The Planning Act 2008

Section 55 Acceptance of Applications*

Section 55 Application Checklist¹

Cleve Hill Solar Park

Title:
Crown Plan in accordance with Regulation 5(2)(n) of The Infrastructure Planning (Applications: Prescribed Forms and Procedure) Regulations 2009
Sheet 1 of 3

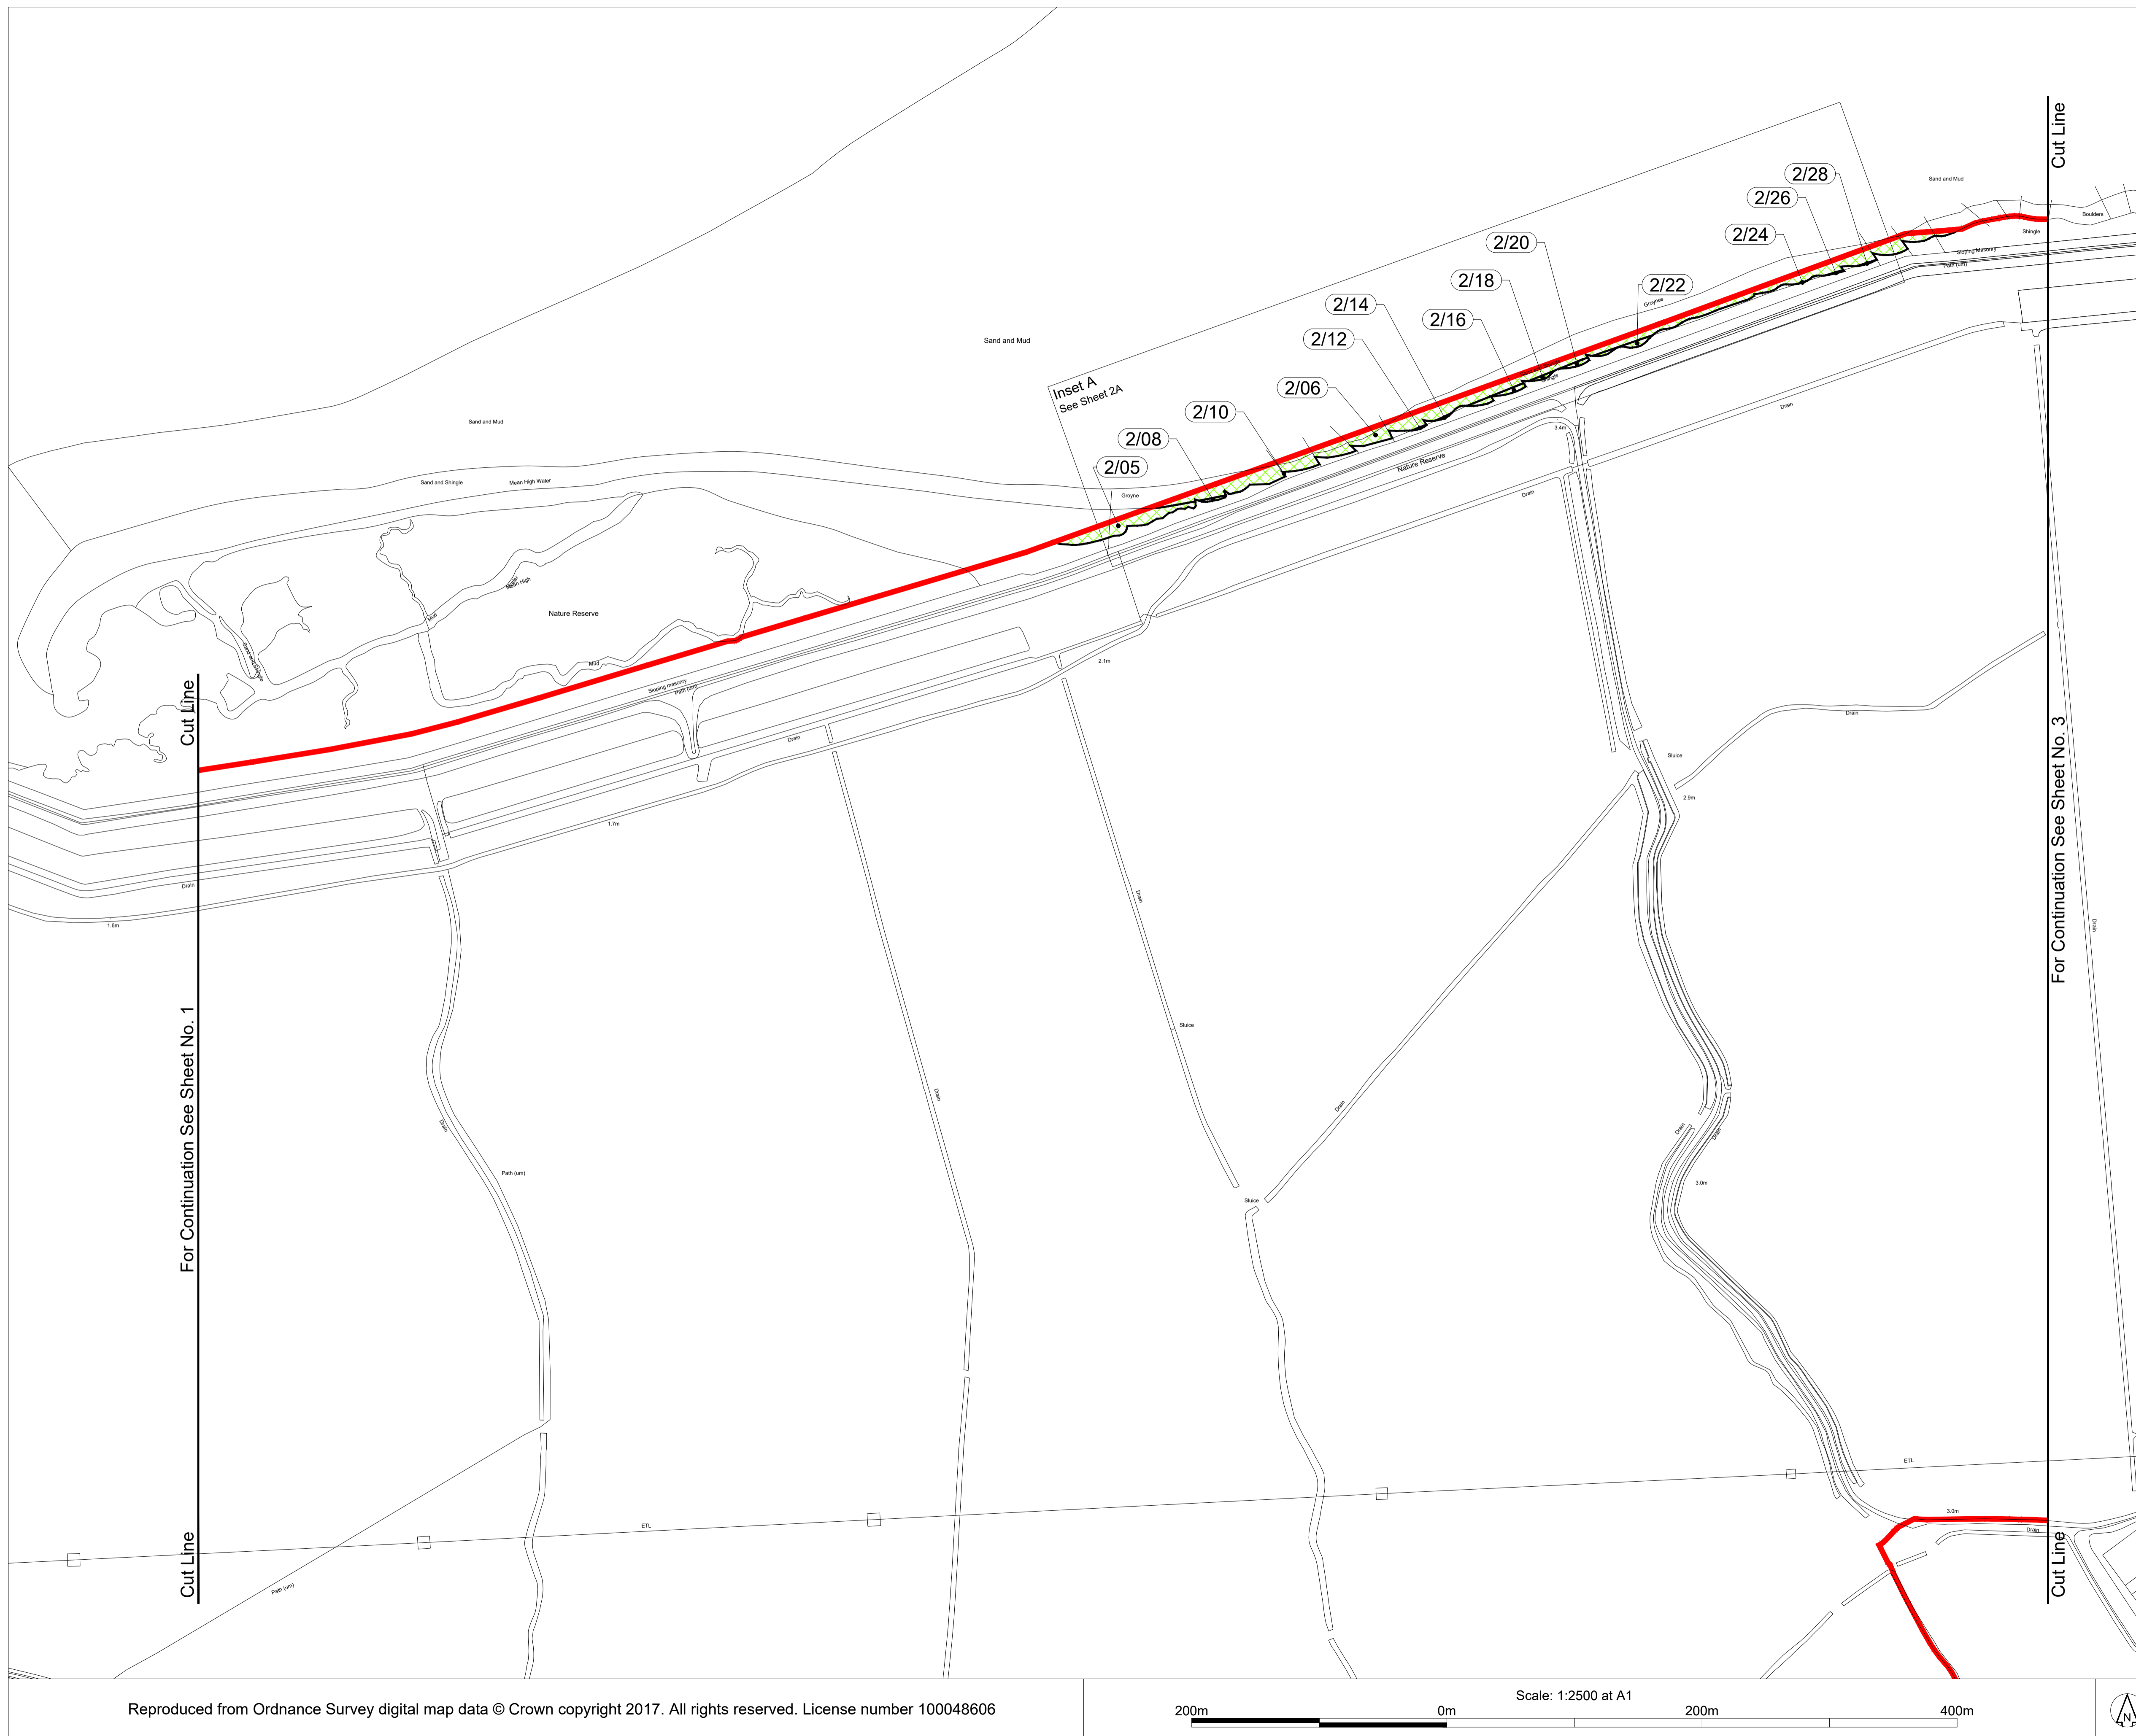
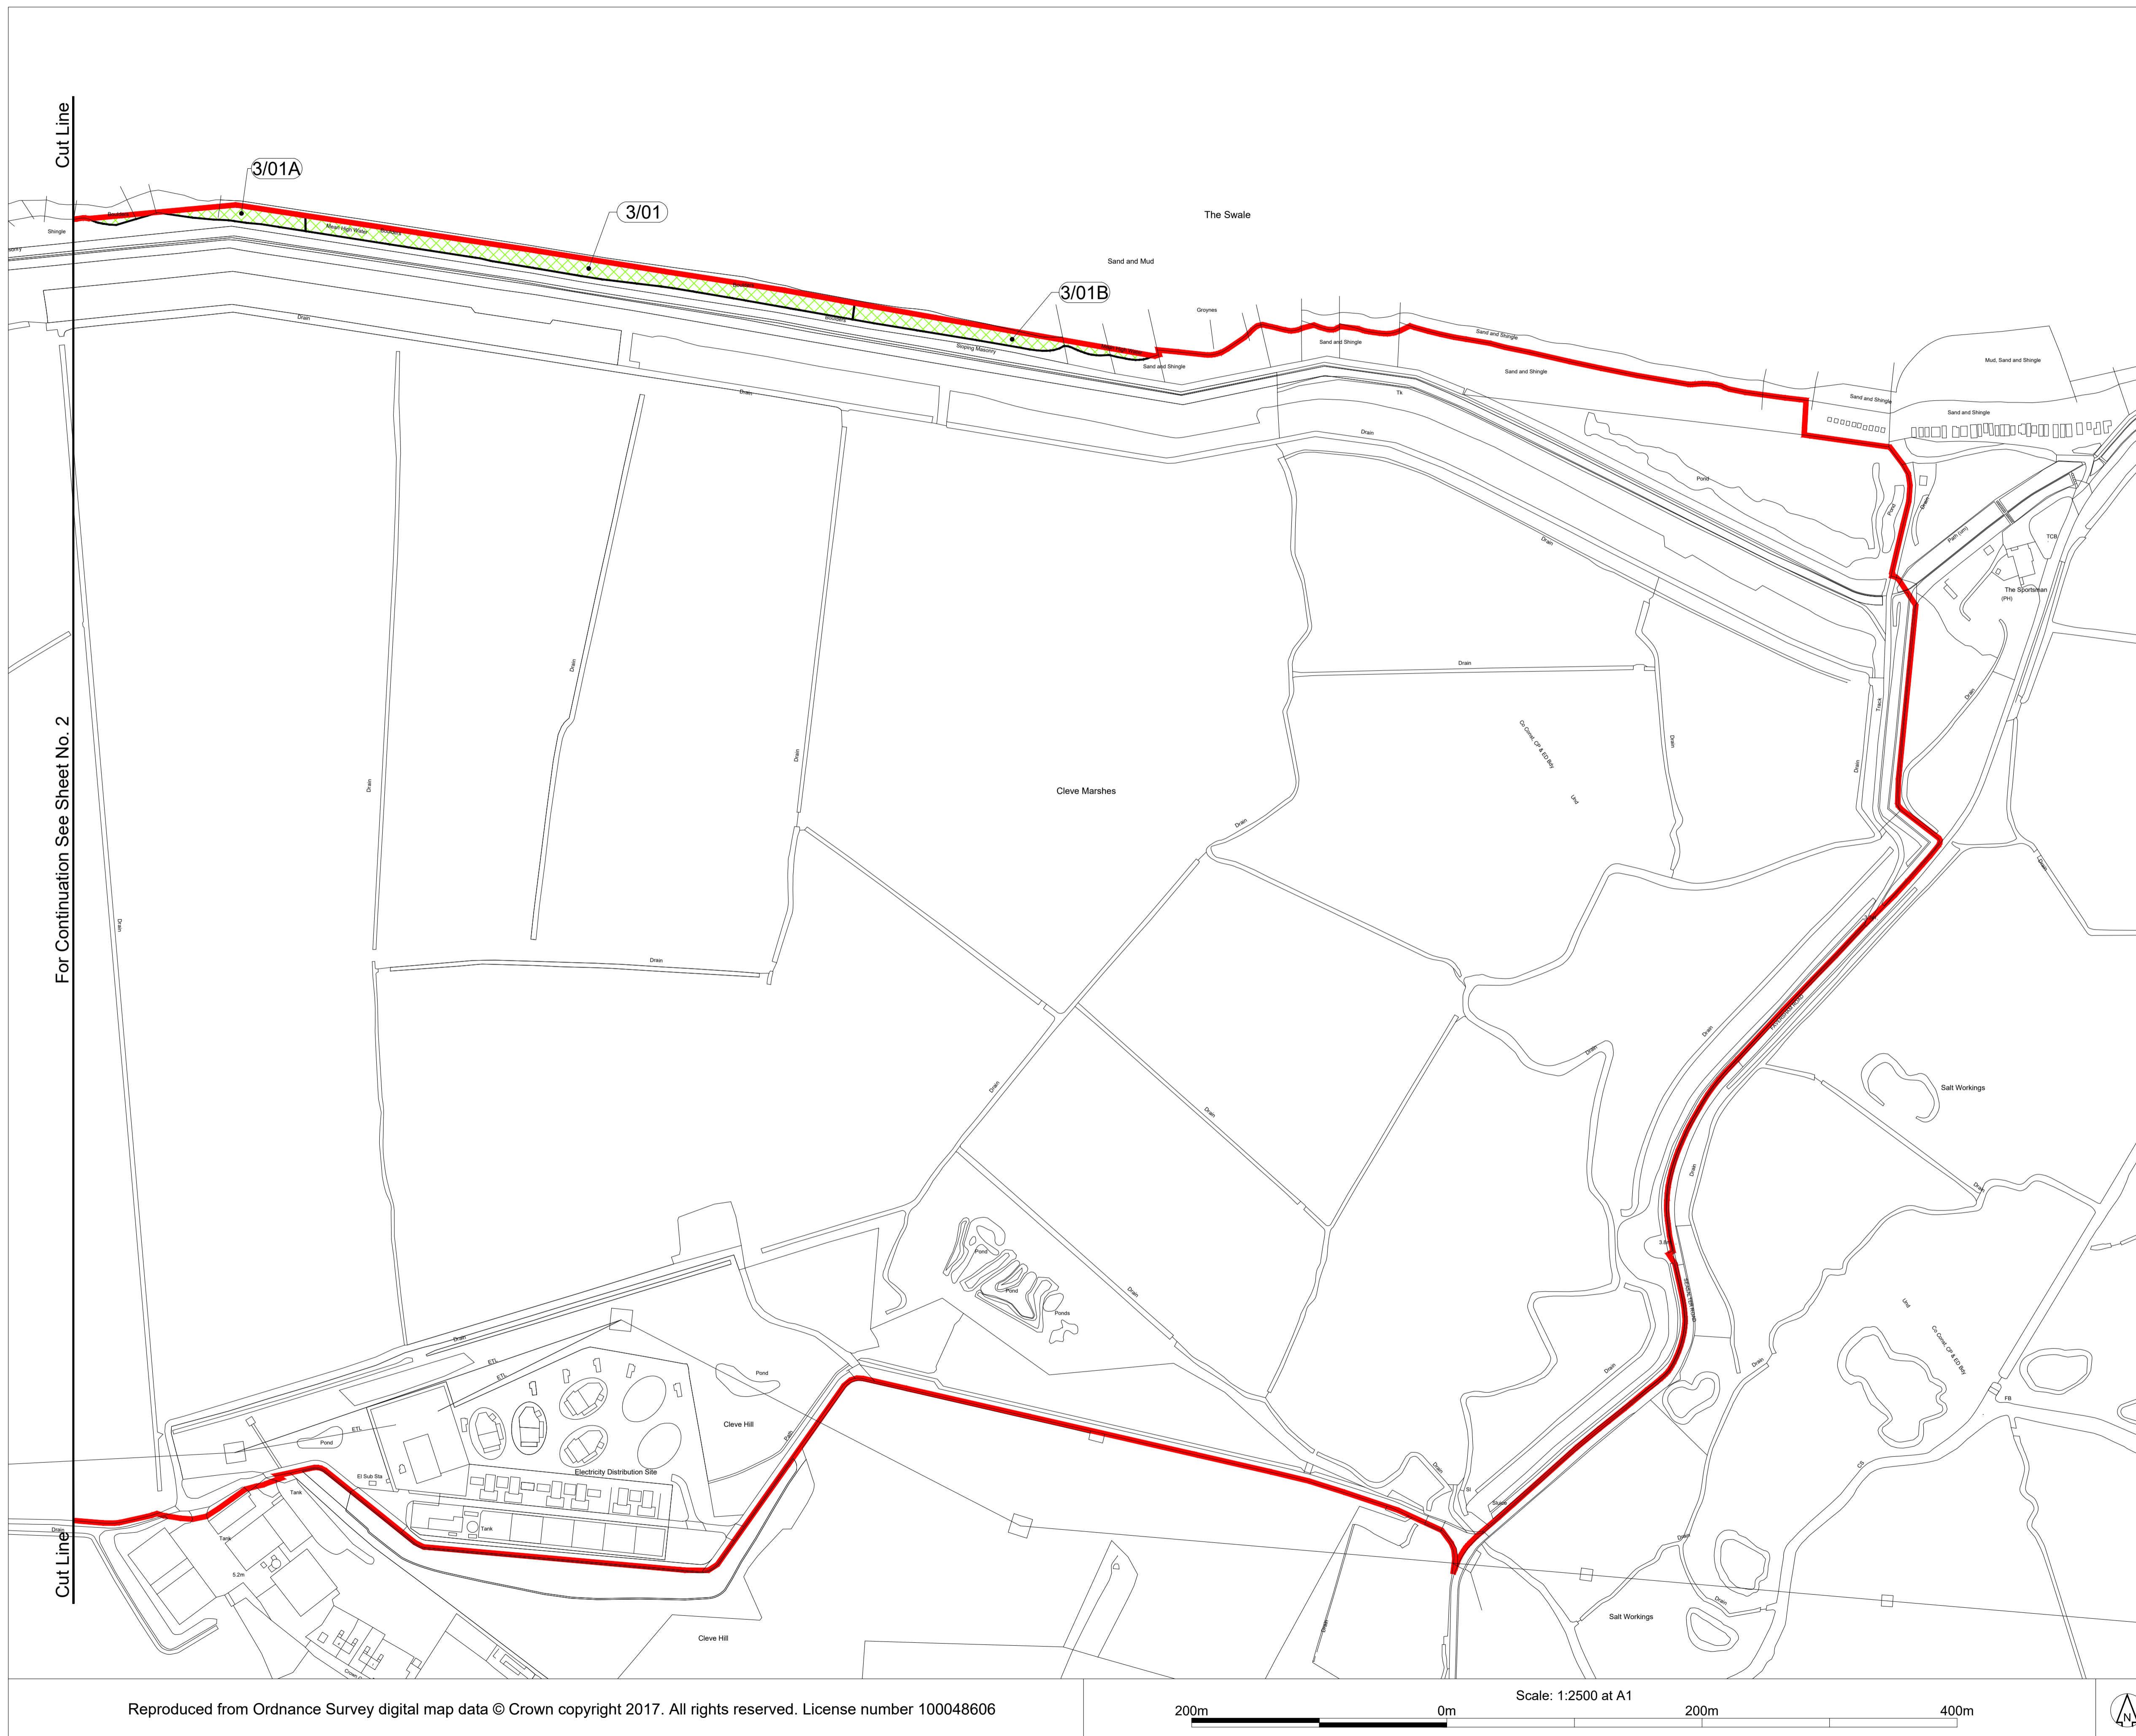
<p>DCO.</p> <p>Regulation 5(2)(n)</p> <p>Crown Land Plans</p> <ul style="list-style-type: none"> The inset sections detailing the smaller plots (used on the land plans (Doc Ref 2.1) are missing from the Crown Land plans – this can make seeing the affected plot difficult without also viewing the land plans. <p>Regulation 5(2)(q)</p> <p>Documents necessary to support the application</p> <p>The Applicant submitted the following additional documents; Outline Design Principles; Mitigation Schedule; Statement of Need; Planning Statement; Statement of Common Ground with Natural England; Heritage Statement; Order limits and Grid coordinates plans; outline construction environmental management plan; outline decommissioning and restoration plan; outline design principles; outline landscape and biodiversity management plan; outline special protection area; construction noise management plan; outline written scheme of investigation.</p>

Title:
Special Category Land - Open Space in accordance with Regulation 5(2)(i)(iv) of The Infrastructure Planning (Applications: Prescribed Forms and Procedure) Regulations 2009

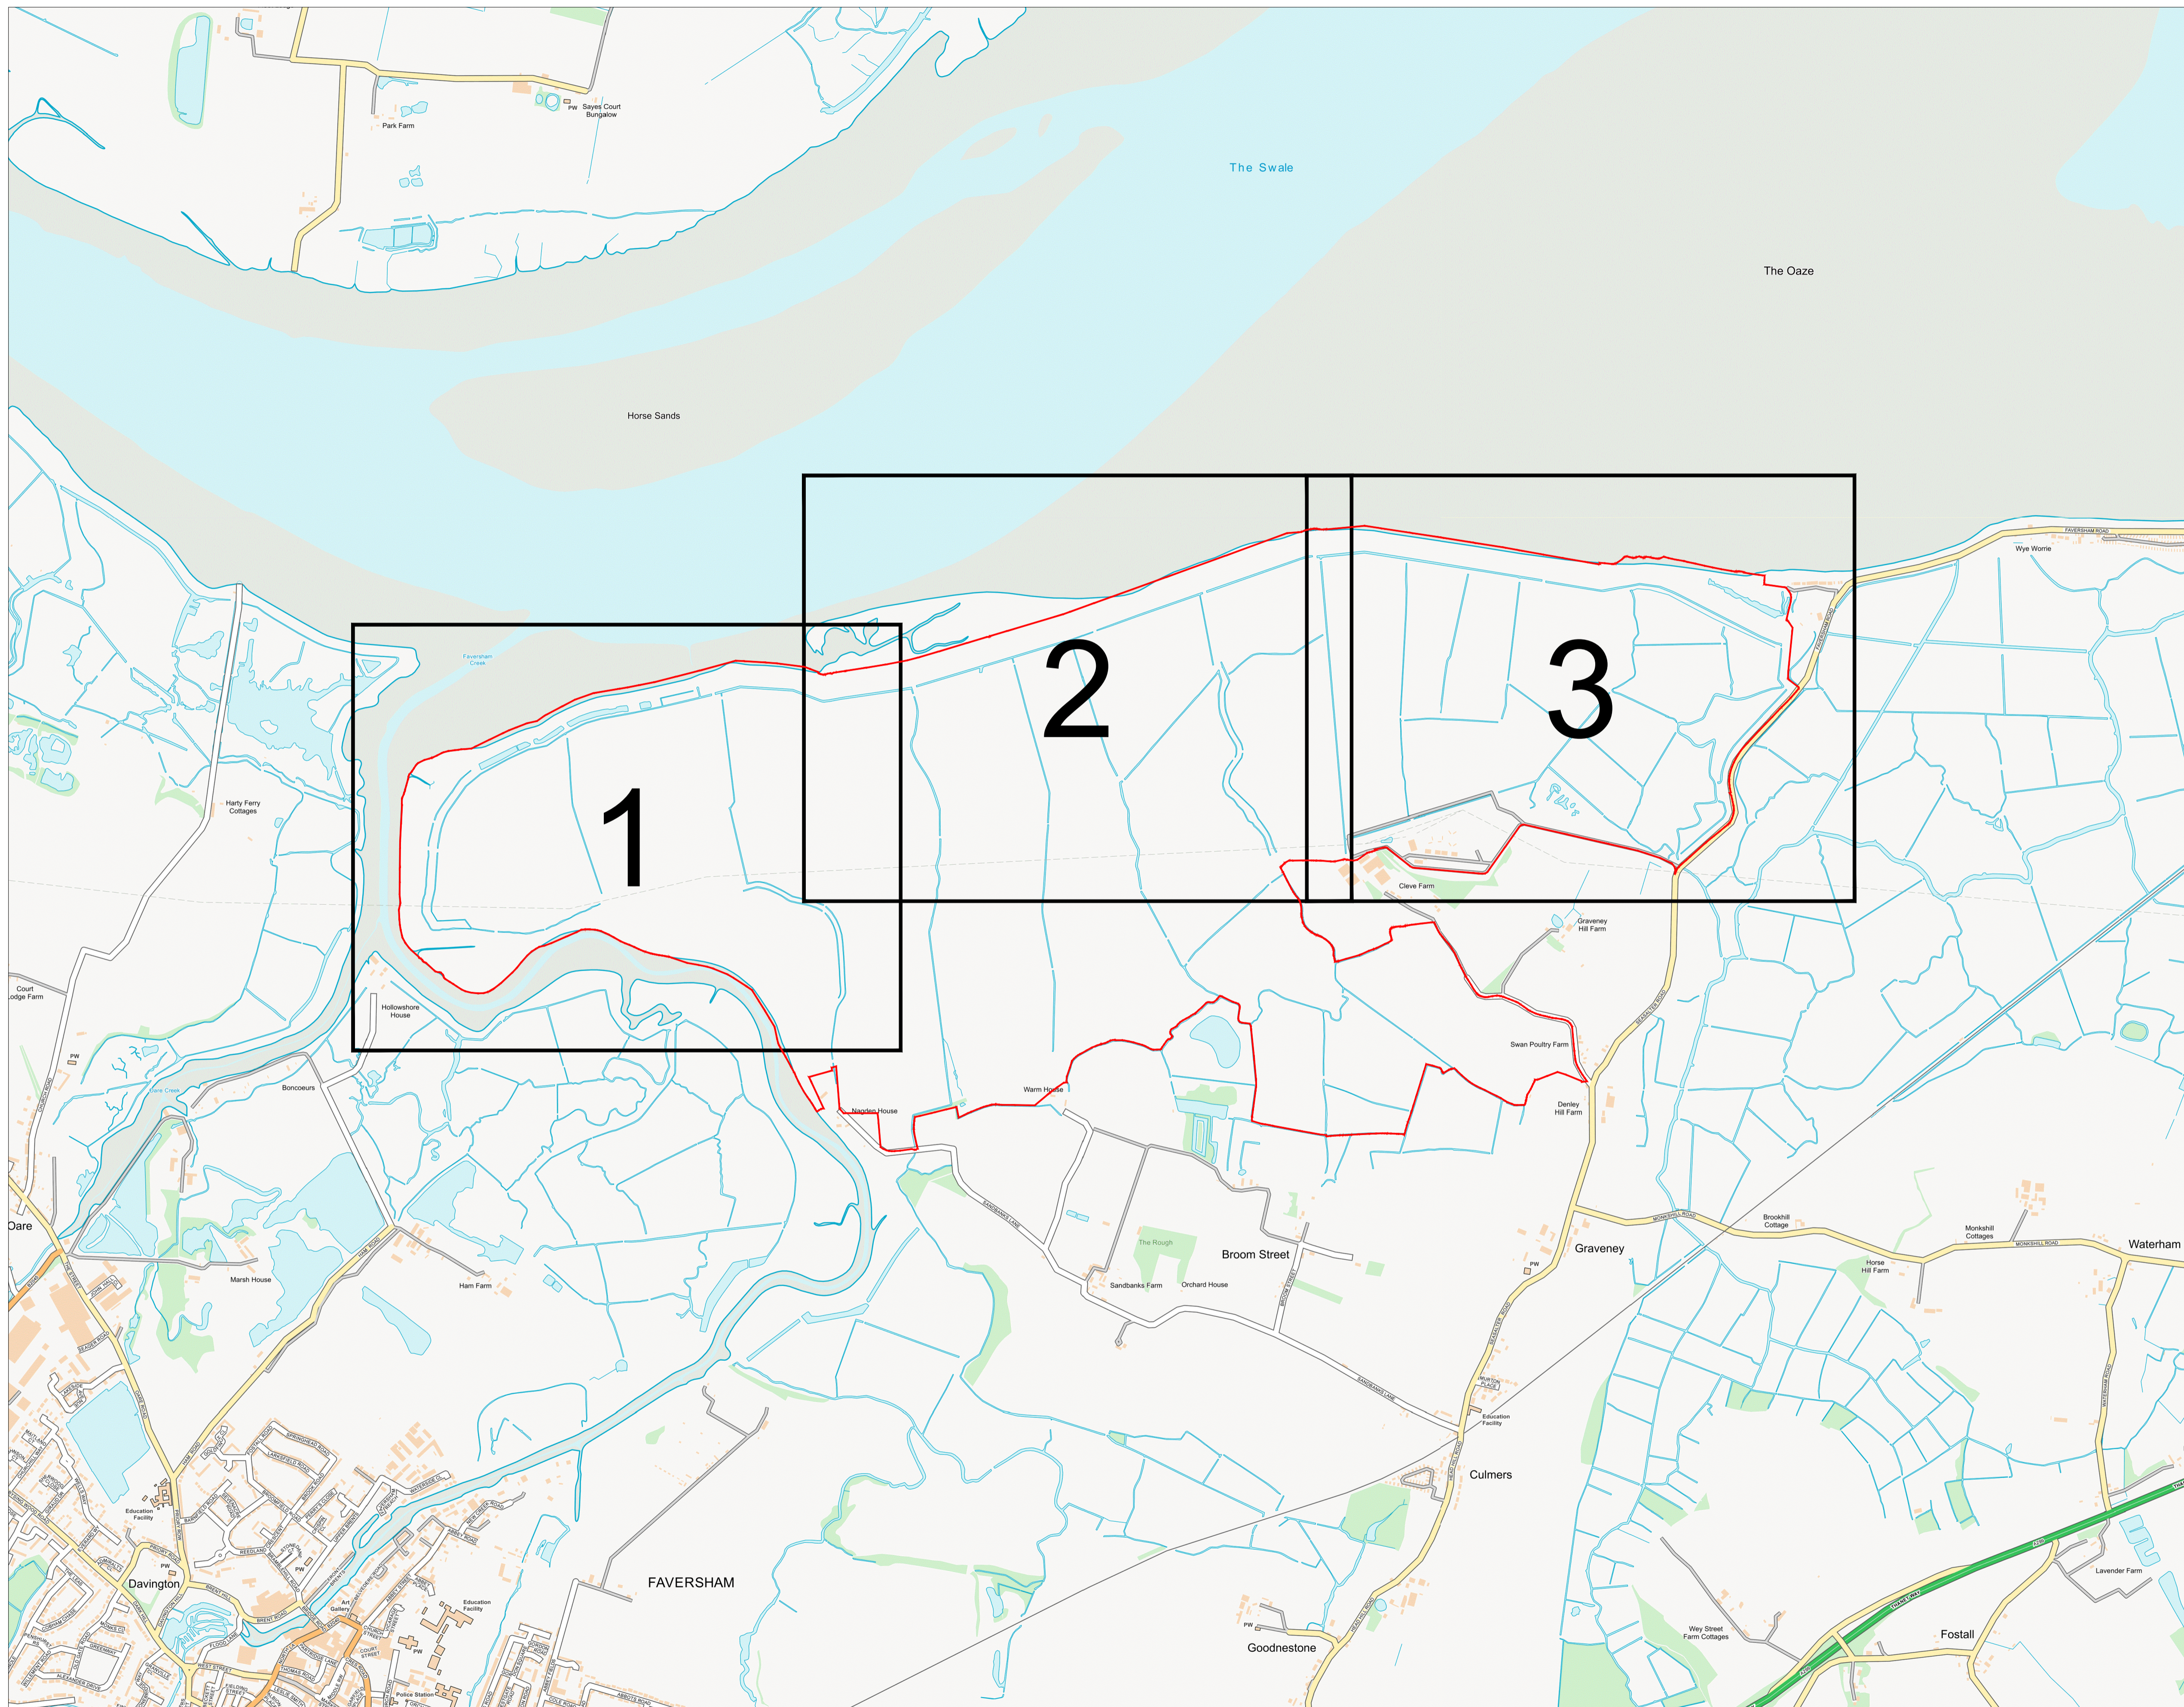
Special Category Land Plans:

- Some plots (1/08, 2/02, 3/02A, 3/02B, 3/10) are subdivided (only a given area of a plot is used for 'open space').
- Plot 1/08 states in the Book of Reference – part 5 that only a part of the plot is required, all other plots where only part of the plot is depicted on the plans as needed for 'open space' just state the plot number.

Plots 4/01 - 4/03 in the Book of Reference are not separately identified on the plans
